27 February 2014

University of Sydney Campus Improvement Program 2014-2020 – State Significant Development (SSD 6123) – Submission and Objection to EIS

01 ENGINEERING - PROPOSED ENVELOPE PLAN

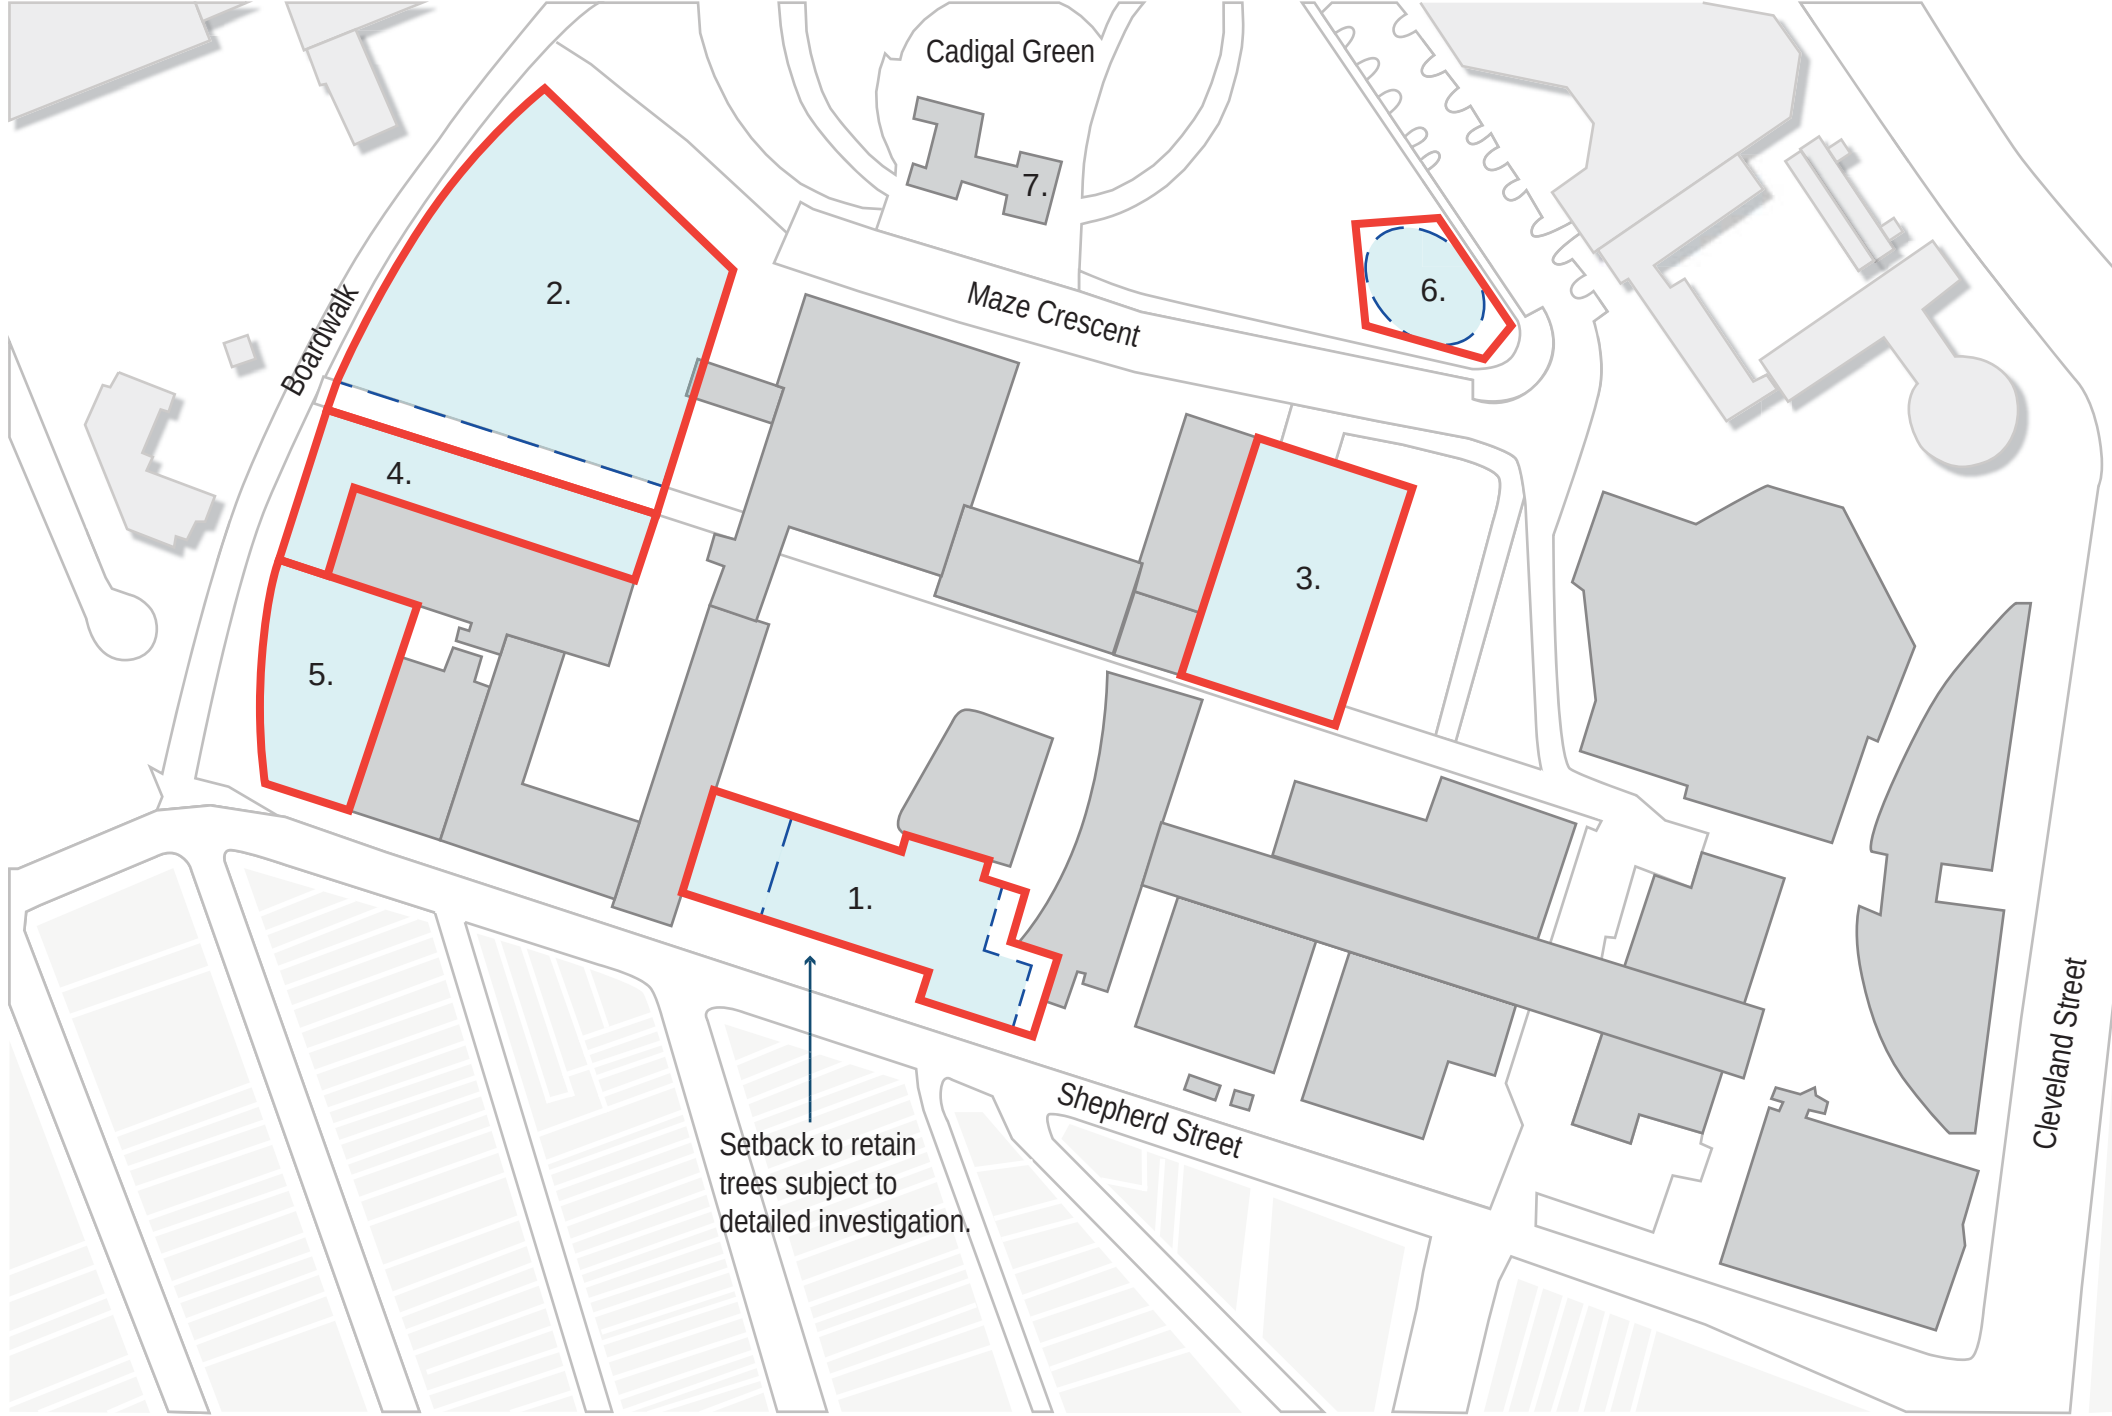
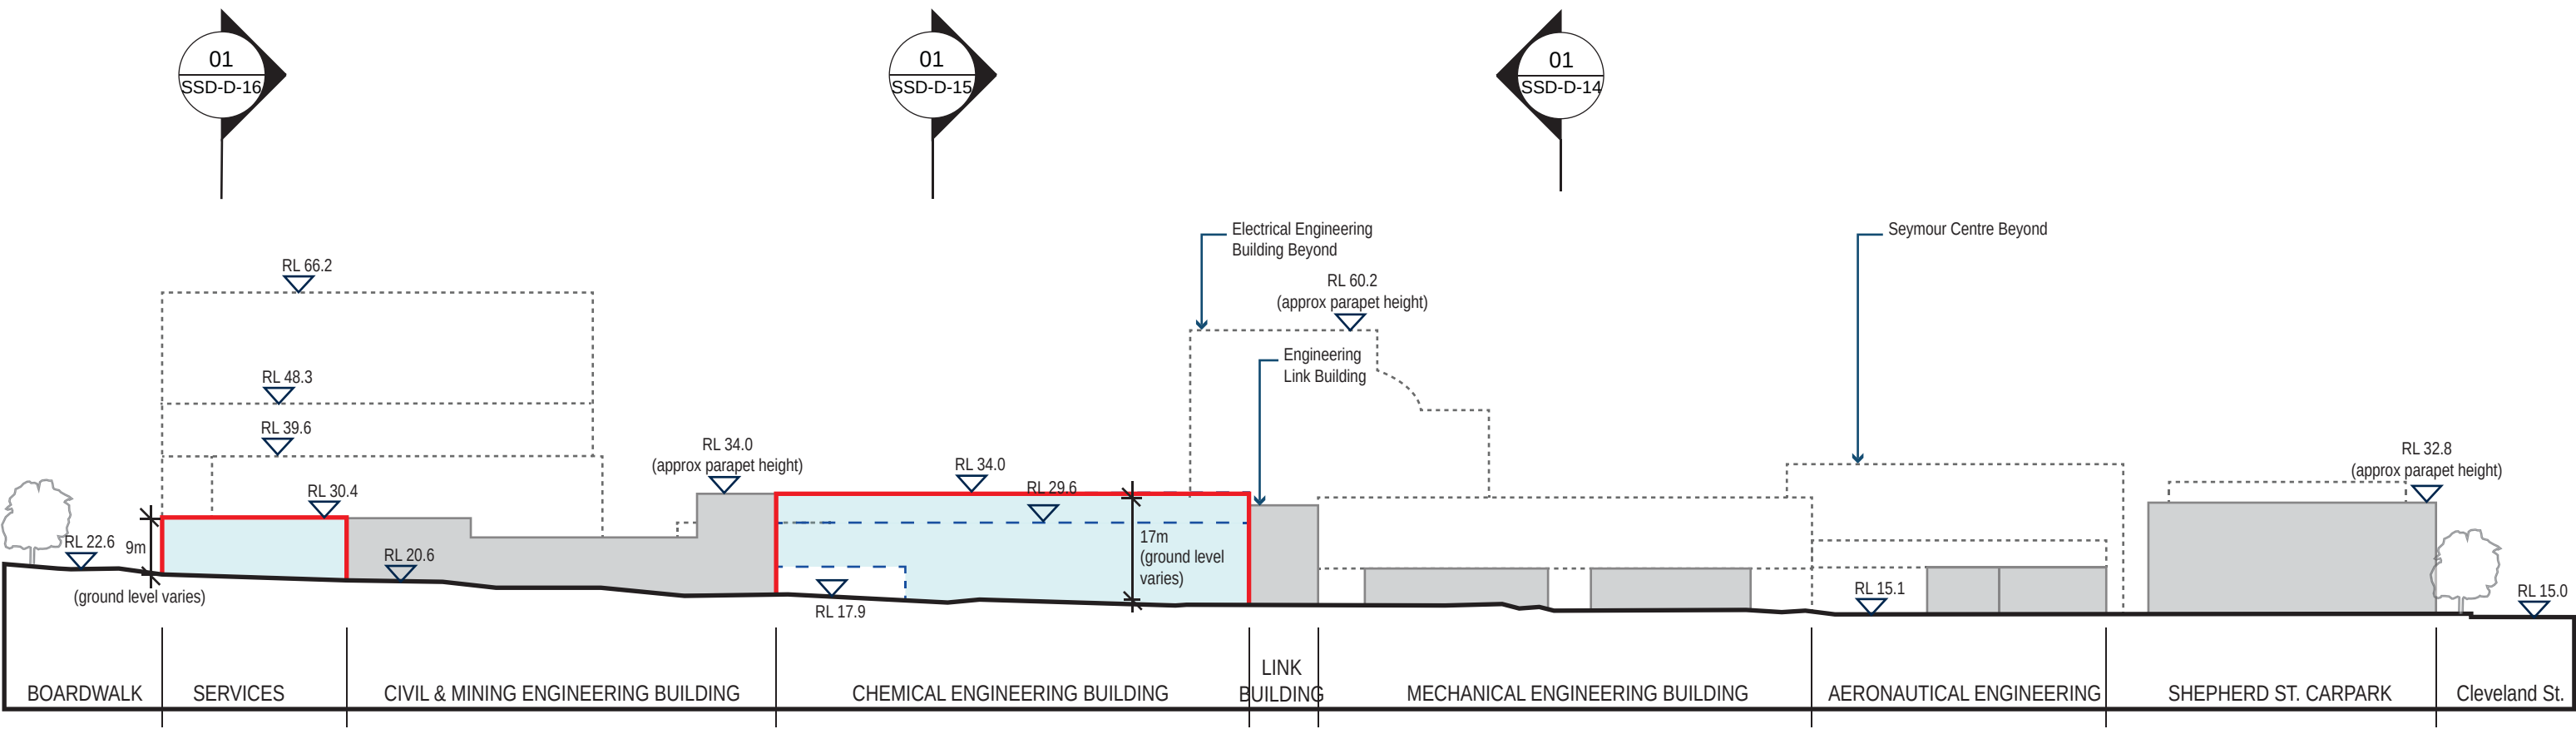
One of the proposals of the University revealed in the EIS is highly objectionable. This is the proposal to remove the stand of eucalypts (species not confirmed but probably Tallowwoods) near the Engineering School on the Darlington Campus. This stand of well-advanced trees and the green hedge along the University's boundary with Shepherd Street is the only significant break in the more than 400 metres of mostly ugly University buildings that extend from Cleveland Street to Lander Street. This grove of Eucalypts acts as a much needed screen for the University buildings from surrounding areas of Darlington; it has high aesthetic values; it provides a refuge for birds and other wildlife; and it is an important amenity for the University and its neighbours. The site in question also has utility value as the trees stand on a car park that is important in alleviating the pressure from the University on kerbside parking space in Darlington streets. Both the trees and the car park are to be negated in favour of a new building that would apparently occupy the whole site.

None of the above statements in the EIS can be easily reconciled with the University's plan to cut down the grove of eucalyptus trees on the Engineering precinct's Shepherd Street car park, to remove this peripheral car parking facility, and to erect on it a three story building close to the University boundary on Shepherd Street.

The forgoing statements in the EIS seem illogical. The EIS proposal is to develop a three-storey building on the Engineering precinct car park. If there ever were a possibility of opening up a 'vista' from Shepherd Street to Cadigal Green (which is doubtful), the planned new building will prevent it.
